**APPLICANT'S COMMENTS ON THE OTHER
PARTIES EXQ2 RESPONSES**

PINS project reference: WS010005

PINS document reference: 15.3

Report Reference: AU/KCW/LZH/1724/01/15.3

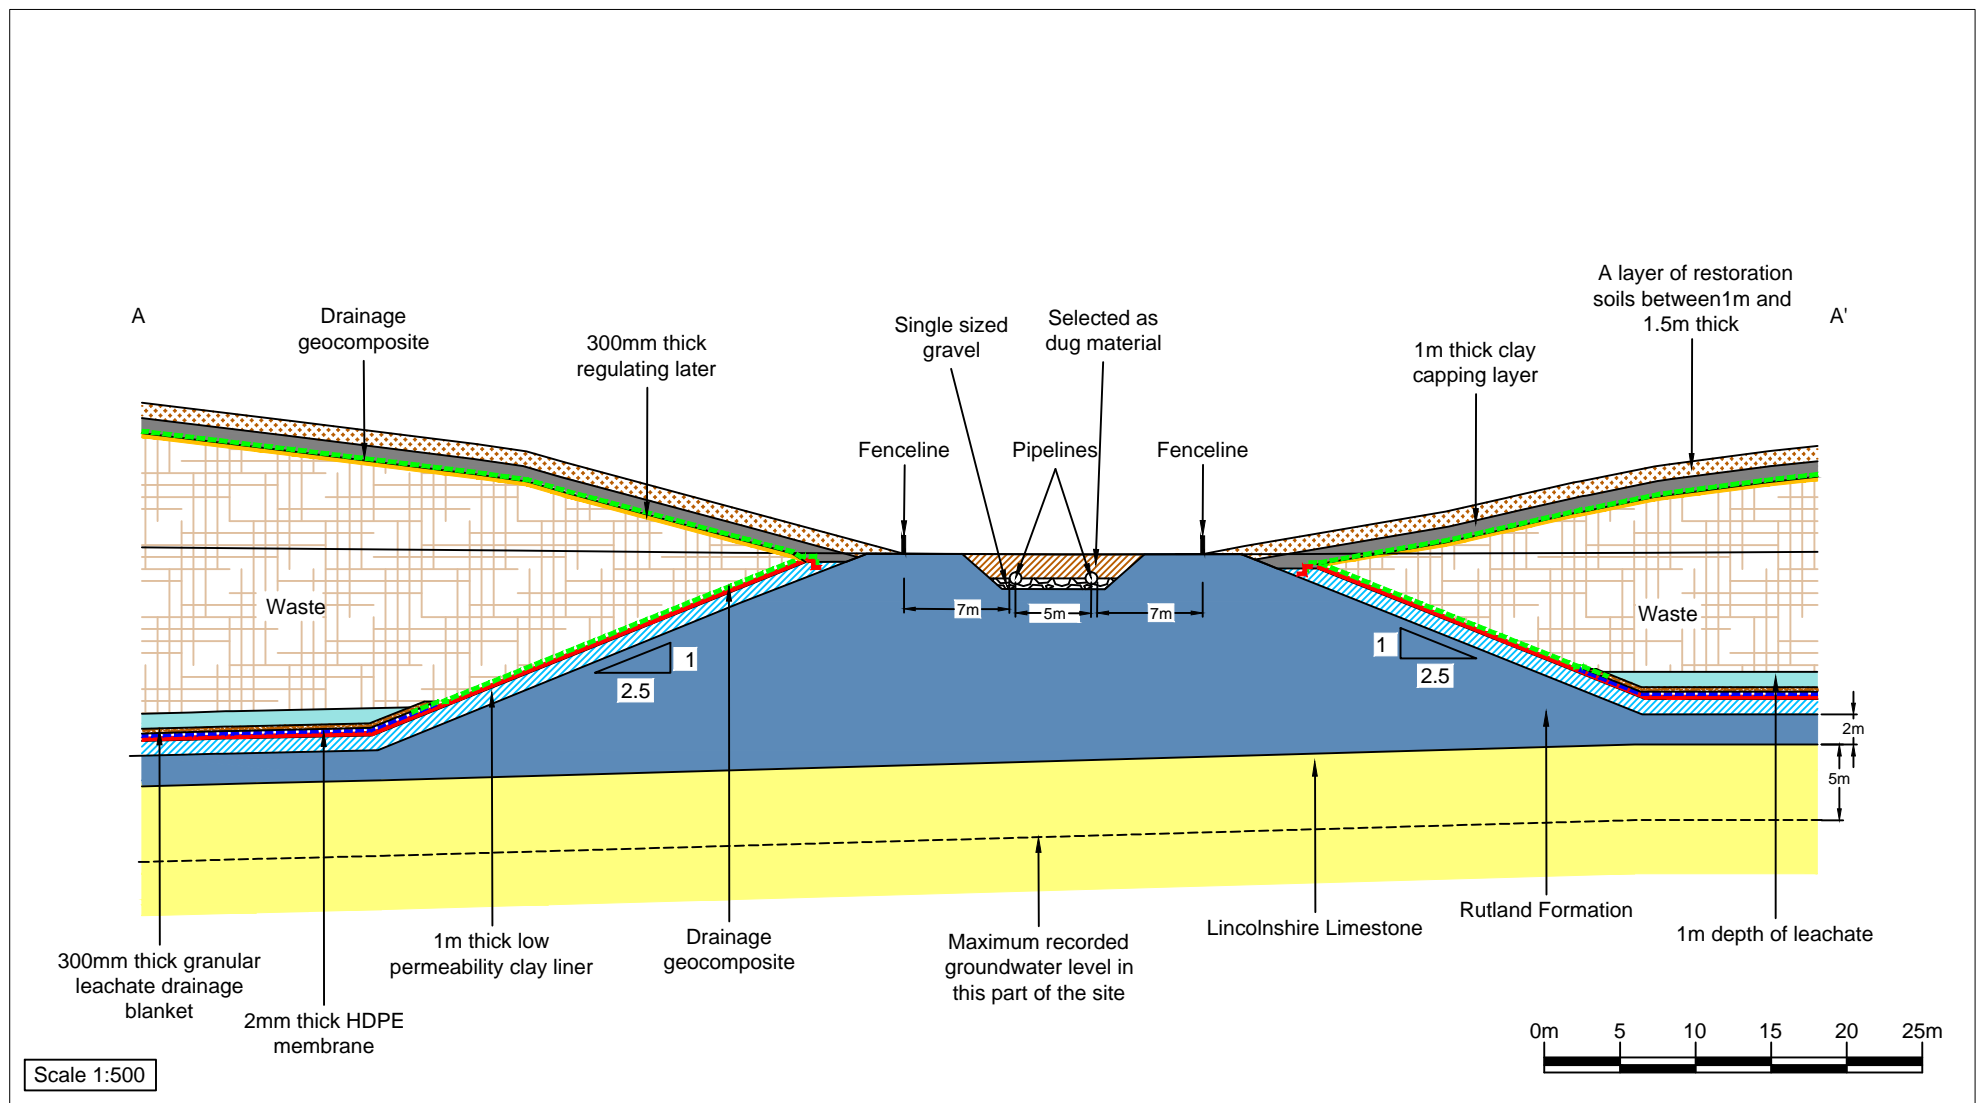
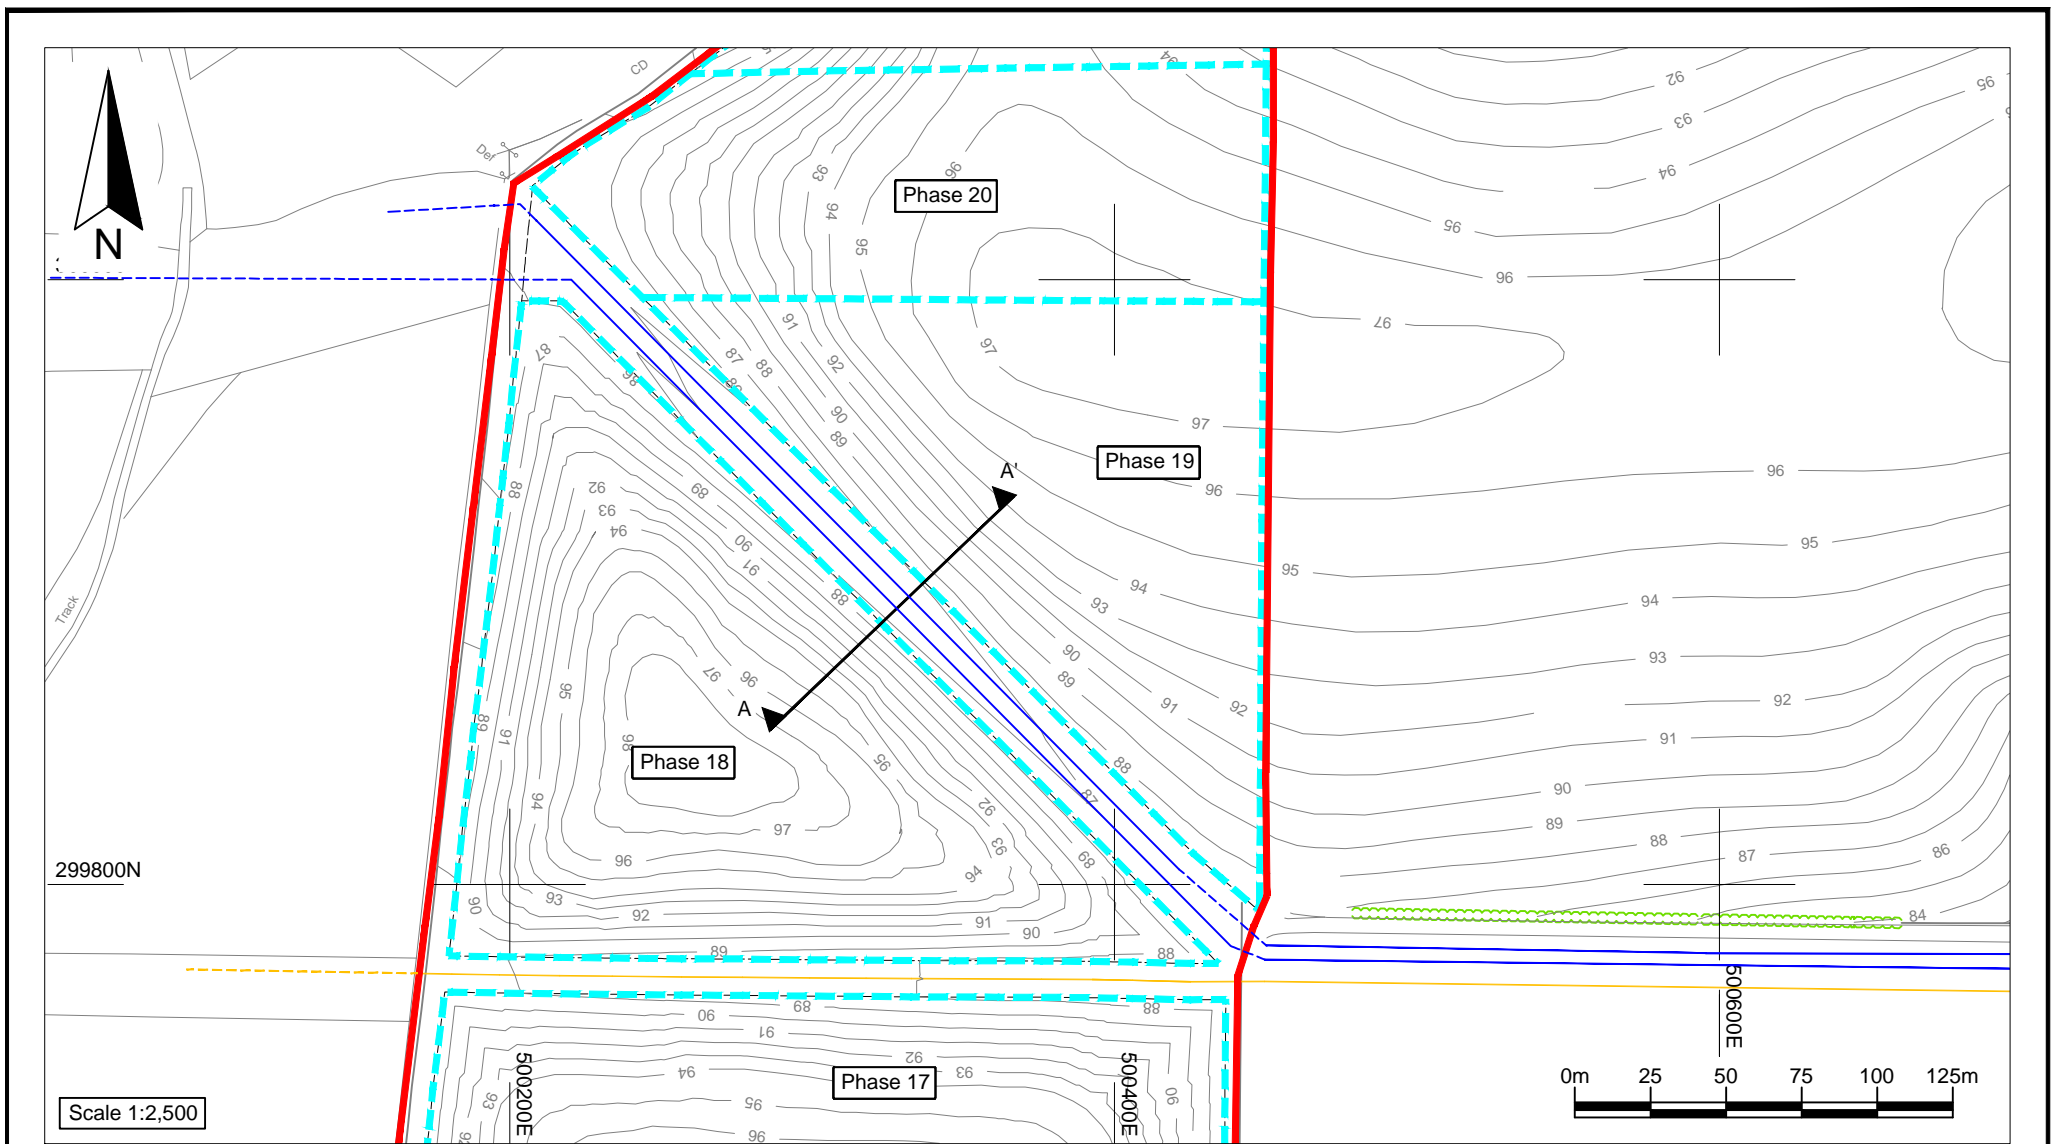
Comments from AG to Examiners questions 2	Response from the Applicant
<p>Q8.4 Please expand on the concerns set out in your D4 submissions [REP4-013 and REP4-014] with particular regard to: a) quantification of the increased risk of failure of an AW pipeline as a result of the Proposed Development;</p>	
<p>6. Our networks are assessed in accordance with our risk model, the Monte Carlo technique, which is an established mechanism. This is an industry accepted standard which takes account for age, pressure, population served and ground conditions which gives us a risk factor (or likelihood of) failure within a given time period.</p>	<p>6 & 7. The Applicant notes that the results of the analysis presented on the plan provided with the Statement and show that for a main of this type there is a low risk of failure.</p>
<p>7. Using the Monte Carlo technique I have carried out a network analysis around the Mains. A copy of this analysis can be found at pages 1. The analysis, and therefore theoretical position, for a main of this type would suggest that it is low risk. However, the model would have assumed that the Mains are undisturbed and loaded as by occasional agricultural equipment. It does not account for the fact there are two mains there, so the risk is at least doubled (as is the level of potential damage) as well as, crucially, the unique and so far undetermined consequences of Augean’s Proposed Development.</p>	<p>6 & 7. The results of the analysis presented on the plan provided show that for a main of this type there is a low risk of failure. The risks specifically relating to the development have been assessed and the results are presented in the pipeline engineering assessment report [14.6.2.3] and the Pipeline Risk Assessment report [14.6.2.2] submitted with the non material change request on 16 June 2022.</p>

<p>8. As previously noted there has already been a leak recorded in the proceeding section of one of the mains. I understand that this leak was caused by local corrosion to that section which in turn may suggest more aggressive ground conditions in this area than our risk model currently accounts for.</p>	<p>6 & 7. No detail of the incident or of the model are provided to be able to comment directly on this point. The greatest potential type of failure, if there is any failure at all, would be a leak. If a leak is undetected and unresolved, there is the potential, albeit very low, that the weakness in the pipe could increase and that a catastrophic failure could occur. It is understood that due to the method of operation of the pipeline, in which the flow is not pumped but is driven by gravity feed from the Wing Water Treatment Works, any loss in pressure resulting from a leak is compensated for by increased gravity flow therefore a leak would not be necessarily detected by a loss of pressure in the pipeline.</p>

Comments from AG to Examiners questions 2	Response from the Applicant
	<p>pipelines, it is considered that any additional monitoring for leaks is not necessary as mitigation as it is not required to control environmental impacts or effects of the proposed development. The option of such monitoring is suggested by the Applicant to provide additional comfort to Anglian Water in order to reach agreement on a sensible standoff distance. Accordingly any commitment relating to monitoring which might be undertaken will be secured through the Protective Provisions with Anglian Water.</p>
<p><i>c) provisions to allow satisfactory access to maintain and repair the pipelines.</i></p>	
<p>20. The bare minimum standard, as per the attached document for this size of pipe is 12 meters (access to twin pipes cannot be across or over the other pipe). However, for reasons outlined above the corridor, especially in the finished condition some years hence when the pipe has advanced in failure risk, will channel any subsequent flows from a rupture directly to the working area and accesses. By diverting the Mains this will allow safe access to the rupture and working zone for further support plant and personnel as required.</p> <p>21. Previously there has been indication that a high voltage cable would be installed near the Mains. If this were to occur we would not be able to safely place mechanical excavation within 3 meters of this, further widening the easement request.</p> <p>22. In terms of an absolute minimum easement width, a theoretical calculation may assume; a 20-tonne tracked excavator allowing 4 meters track extending to 6 meters for slewing, 1 meter minimum for edge of passage, haulage road 6 meter plus a minimum segregated pedestrian walkway of 1.5 meters. This working zone will of course be distanced from the pipeline to avoid loading, and an eruption/excavation crater of a minimum 4 meters (conservative). This would take us to a minimum from edge of pipe of circa 20 meters plus. Whilst it is tempting to assume that in emergency situations, we would compromise these arrangements as an organisation we pride</p>	<p>20 to 22. As stated above, the non-material change request submitted on 16 June 2022 [14.2] demonstrates that the estimates for the space needed for access to the pipelines range from 8.5m to 20m to the side of each pipe therefore 20m is the maximum that is likely to be specified. A total easement width of 40m which is suggested as 'ideal' by Anglian Water in paragraph 17, taking into account the distance between the pipes of 5m and the width of the pipes of 1.6m, correlates to a standoff distance of 16.7m away from each pipe $[(40-6.6)/2]$ which is well within the standoff of up to 30m from each pipe proposed in the non-material change request. It is therefore clear that the standoff now requested by Anglian Water can be accommodated in the application as now proposed including the standoff of up to 30m which is the subject of the non-material change to the application.</p> <p>23. No information was provided on the pipe crossing as it was specifically excluded by Anglian as a matter for consideration at this time [REP4-014]. Based on the assessments carried out [14.6.2.3], it is concluded that a suitable crossing over the pipelines can be constructed readily, using standard methods that will protect the integrity of the pipelines. There will be no need for piling associated with the design of a suitably robust and protective crossing point. A specification for design of the crossing will be discussed and agreed</p>

Comments from AG to Examiners questions 2	Response from the Applicant
<p>ourselves in the fact that nothing we do is so important as not to do it safely, therefore we will not compromise on a safe working zone.</p> <p>23. If the Mains were to remain, the proposed greater easement width would ultimately provide a greater mass stability to the pipe embankment, this is particularly relevant as the information provided to date is silent on the issue of the pipe crossing. Augean intend to cross the pipeline by some form or ramped access or roadway to gain access to the respective phases. I imagine Augean's proposal will include some form of bridged structure, which would most likely be piled, to enable spanning of the Mains and risk of settlement. This position will need to be agreed and undertaken ahead of any excavation to enable temporary works and piling rig access; the additional easement will allow for this potential as it would carry increased risk and cost to try to do this against and excavated areas. To provide piling in this area will itself be a risk to the Mains and would need to be carefully planned.</p>	<p>with Anglian Water at the appropriate time pursuant to the proposed Protective Provisions for the benefit of Anglian Water.</p>
